**MINOR ZONING BY-LAW AMENDMENT APPLICATION
DELEGATED AUTHORITY REPORT
MANAGER, DEVELOPMENT REVIEW**

Location of Minor Re-zoning: 2983, 3053 & 3079 Navan Road

File No.: D02-02-26-0010

03 SITE PLAN
SP-A01 SCALE: 1:250

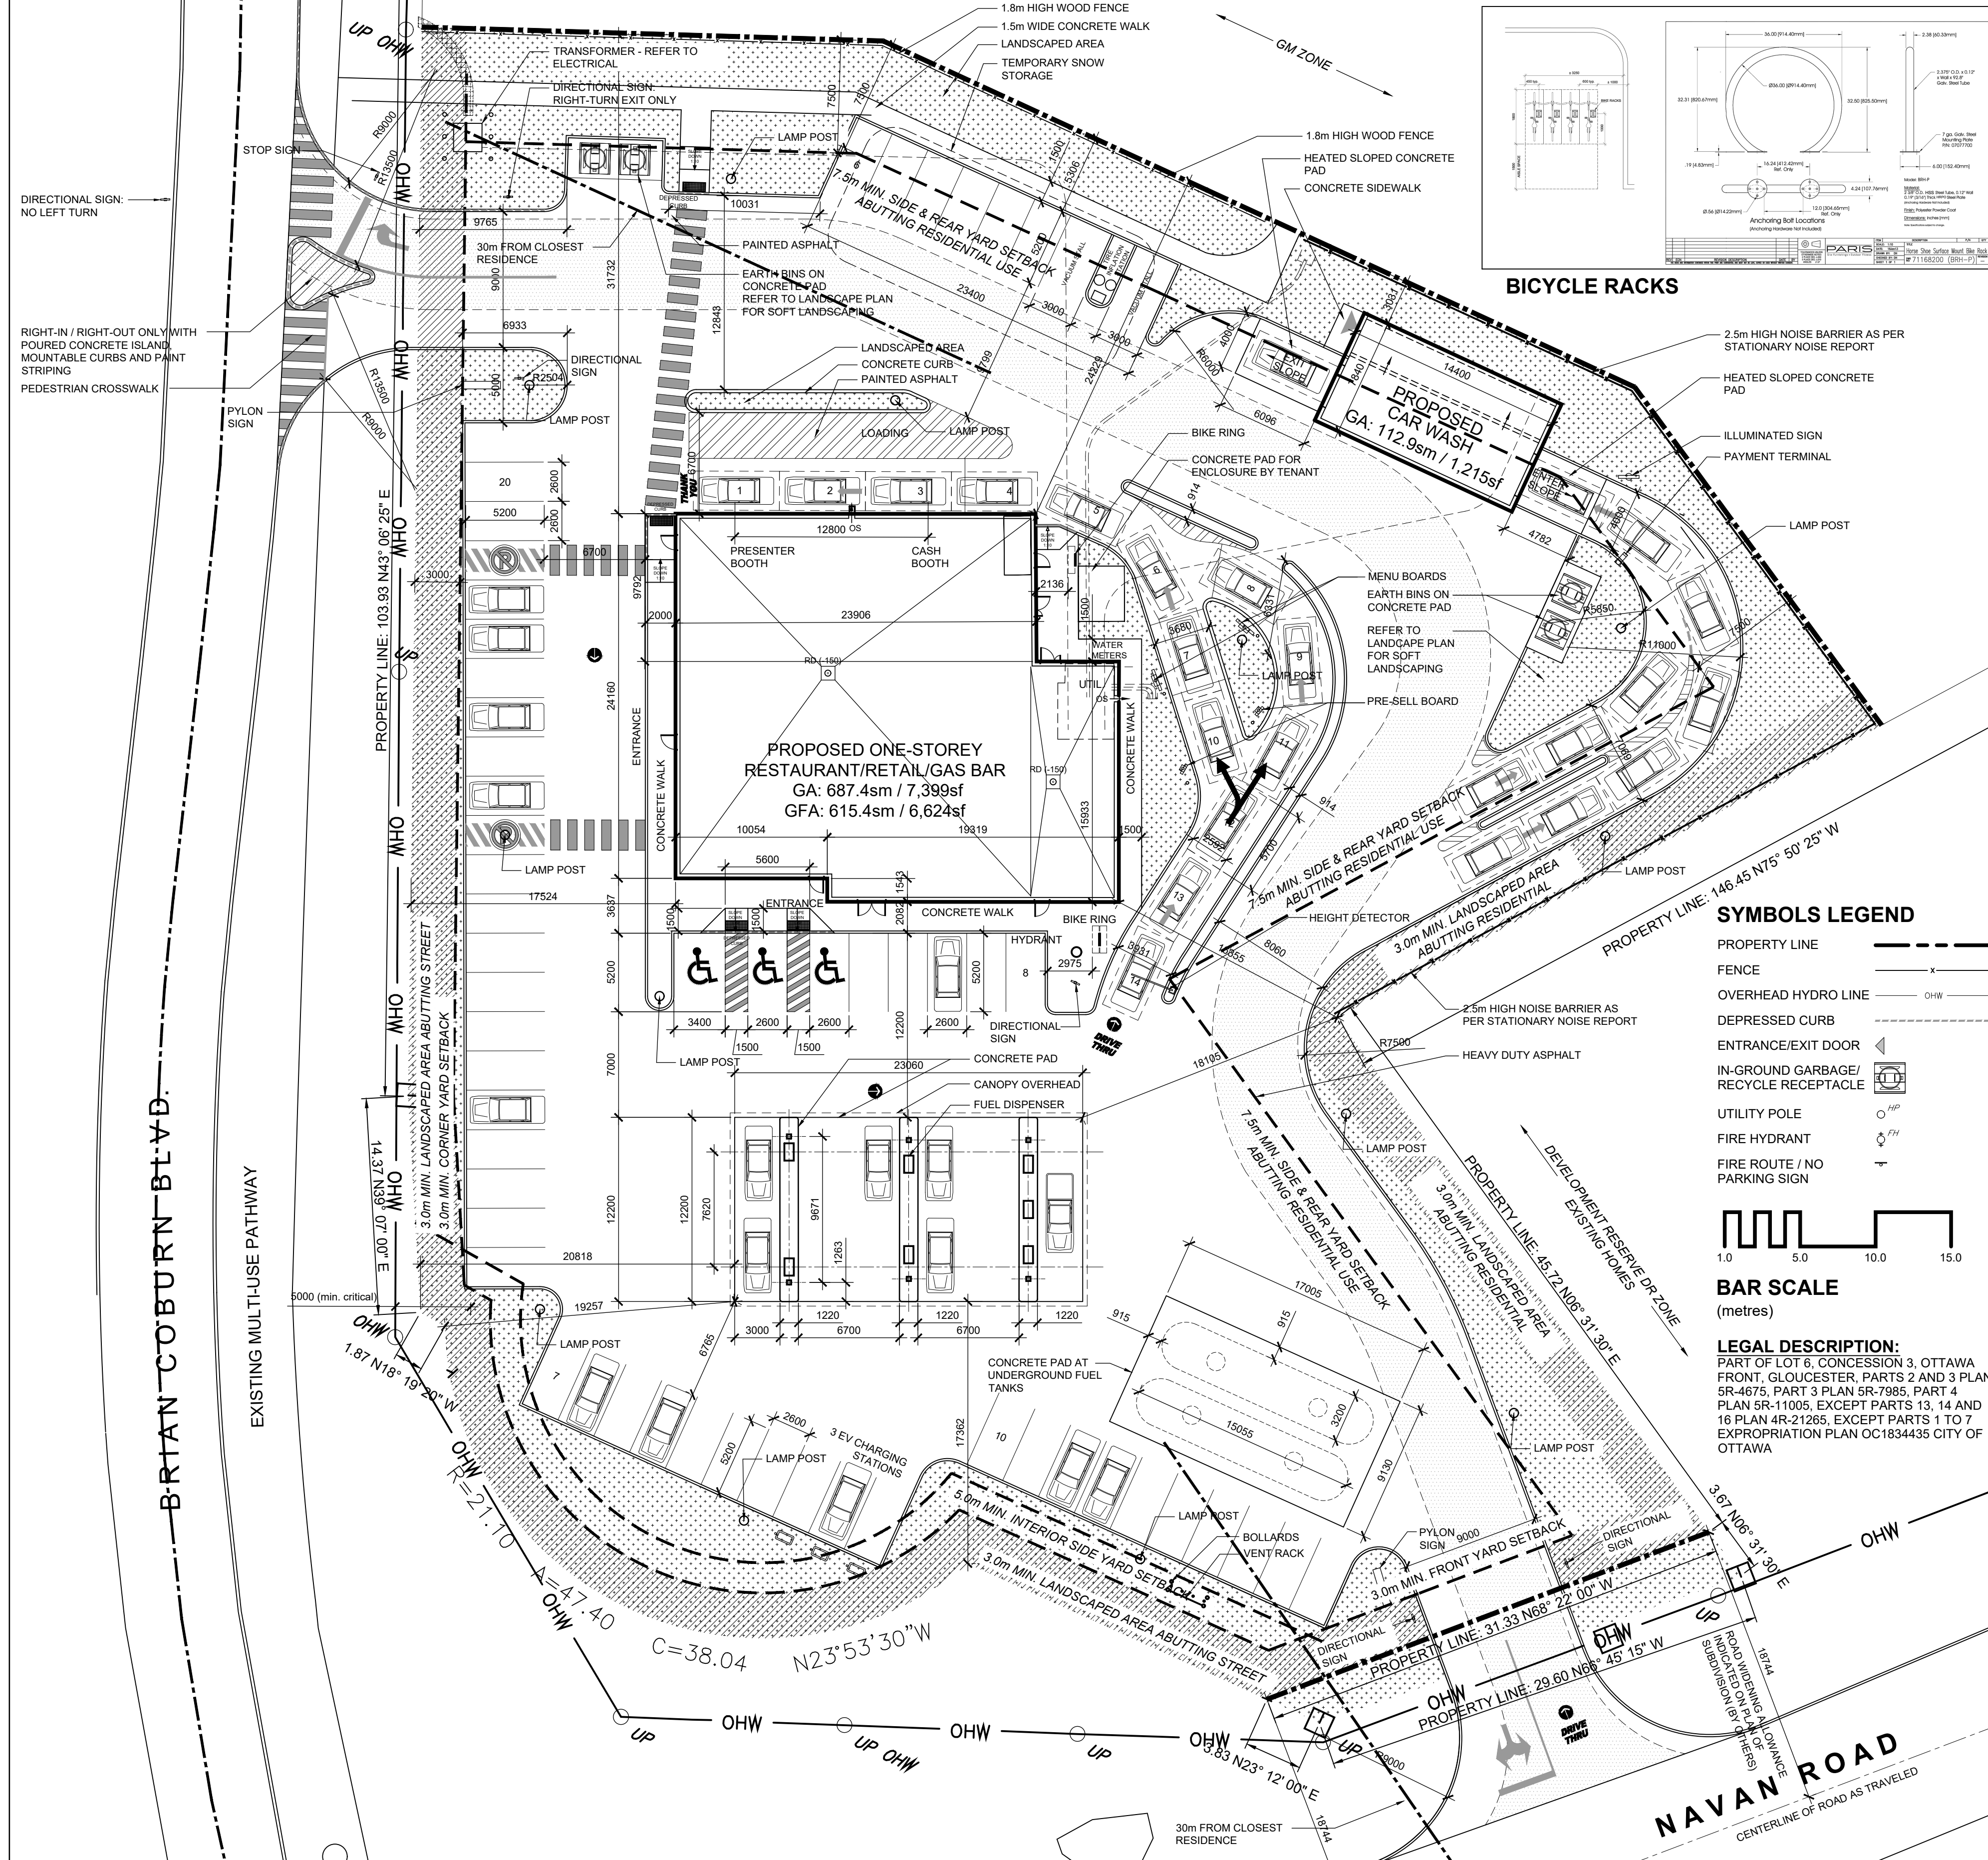
However, one request stands out: the proposal for Block 16 to reduce the required setback between a car wash and the adjacent residential property.

While the applicant has proposed mitigation measures, I remain concerned about the proximity of this use to future homes.

A car wash is not a passive commercial use. It involves mechanical equipment, vehicle queuing, and activity throughout operating hours. Even with mitigation measures in place, locating this use significantly closer to future residential units than originally envisioned raises legitimate questions about the long-term quality of life for residents.

The row townhomes planned along the southwest side of Paleo Heights Private will be directly affected by this new interface. Although the residential block will provide its own 7.5-metre rear yard setback, the reduction on the commercial side still brings the car wash substantially closer to those homes than the zoning framework originally contemplated.

From my perspective, the intent of the original setback requirement was to ensure a meaningful buffer between a higher-impact commercial use and residential living spaces. Reducing that separation by more than half undermines that intent, even if other mitigation measures are in place.

The Applicant provided a Noise Study that evaluated the noise levels on the surrounding properties. The recommendation is to have a 2.5 metre tall noise attenuation fence on the property line. The fence is on the Site Plan that is to be approved by Staff. The conclusion was that noise in the rear yards was within the City's Noise Guidelines and that moving the Car Wash further from the lot line would have no negligible improvement over the proposed condition.
